14 September 2021

Your Ref: SSD-15882721

**Comments on Doran Drive Plaza Precinct
LOT 55 in DP 1253217**

STORMWATER DRAINAGE
PLAN

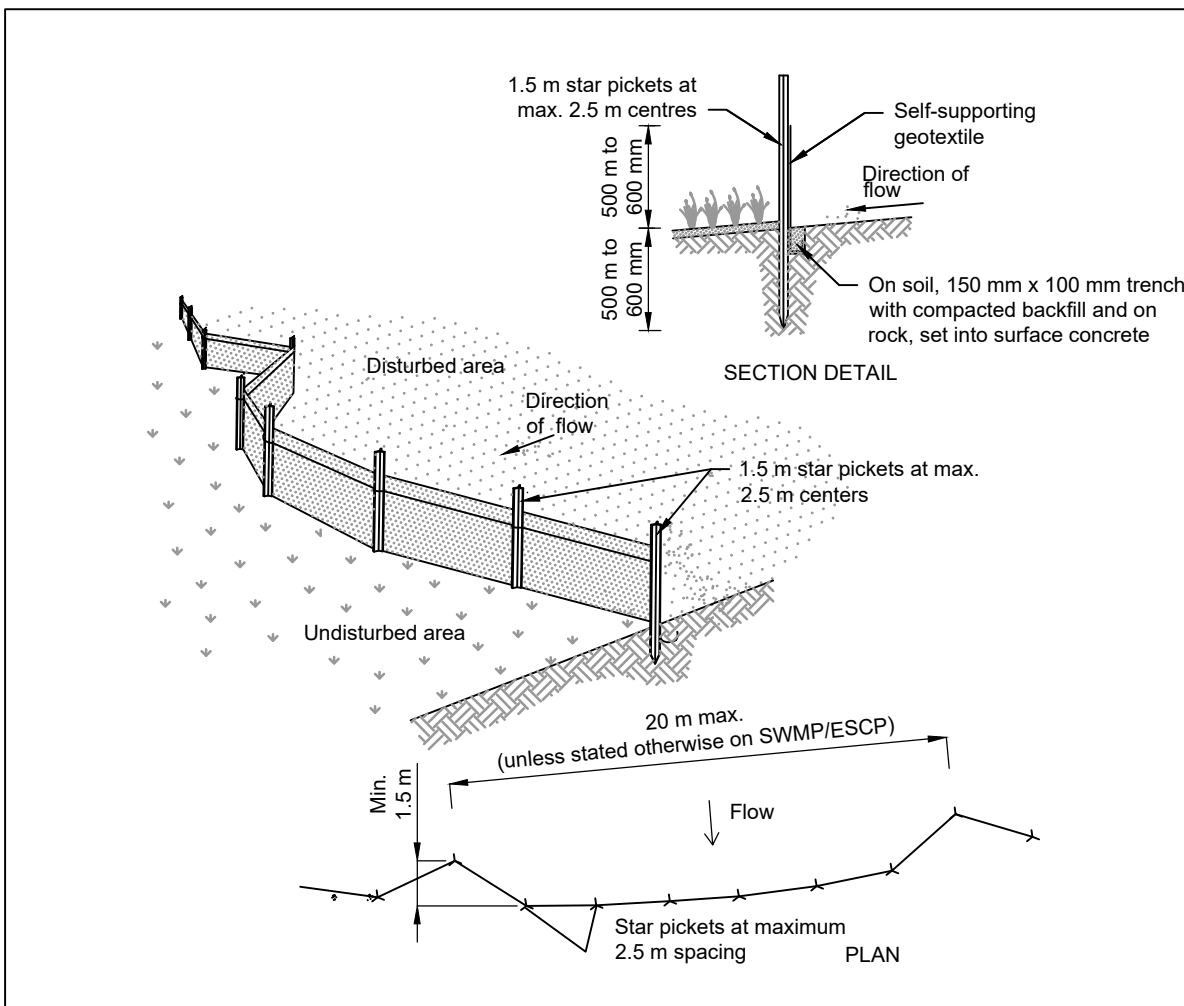
- 1.1. The capacity of the stormwater system into which stormwater from the development discharges into must be checked and analysed. Please note that the check/analysis shall be carried out to the legal point of discharge to ensure that the street pits will not be surcharged during minor events up to the 10 years ARI storm event. Therefore, the Rainfall Intensities shall be updated and consistent with the section 4.10 Council's Design Guidelines Subdivisions/ Developments. Similarly, the duration of the analysis shall be extended to 72 hours. Also, the overflow depth for major storm event shall be Max 200mm not 300mm.

- 1.3. Where the proposed driveway is impacting the existing stormwater pit. The kerb inlet pit must be replaced with a grated/ butterfly lid pit integrated into the new driveway and a new kerb inlet pit must be design upper slope of the butterfly pit.

A	SECTION - OSD TANK
CI-0621	Scale 1:25

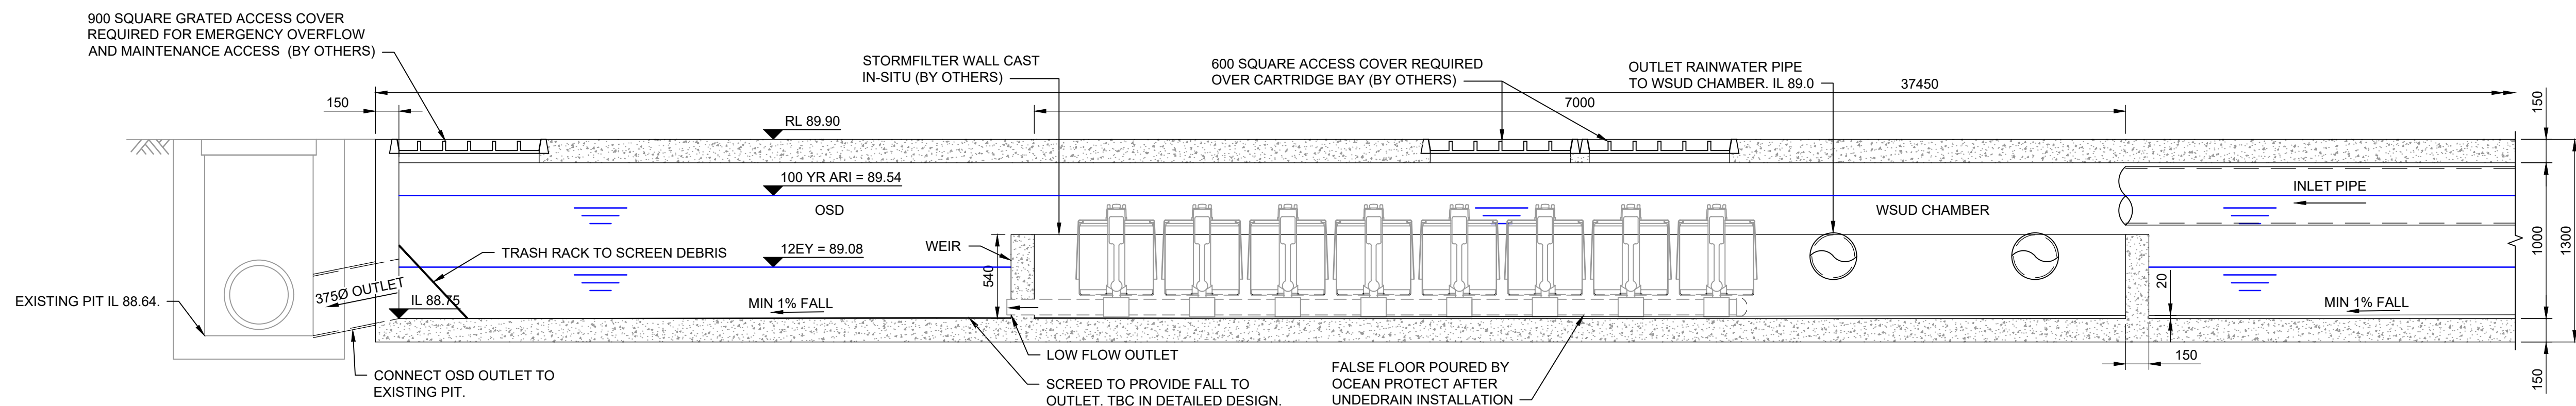
- 1.4. The OSD and Rainwater tanks shall be shown on the architectural plans and relevant sections plans. OSD and rainwater tanks are permitted on common areas only. Rainwater tank and OSD underneath the tenancy/habitable area will not be supported.
- 1.5. Any proposed work on council's land/road due to the proposed development shall be subject/ requires separate approval from Council beforehand via Section 138 of the Roads Act 1993,
- 1.6. When OSD, Water sensitive urban design elements and Rainwater tanks are provided for the development Positive Covenant/Restriction-as-to-use – legal protection placed on a property title requiring owners to repair and maintain the OSD systems
- 1.7. Stormwater and civil works shall be completed as part of stage 1 of the development.
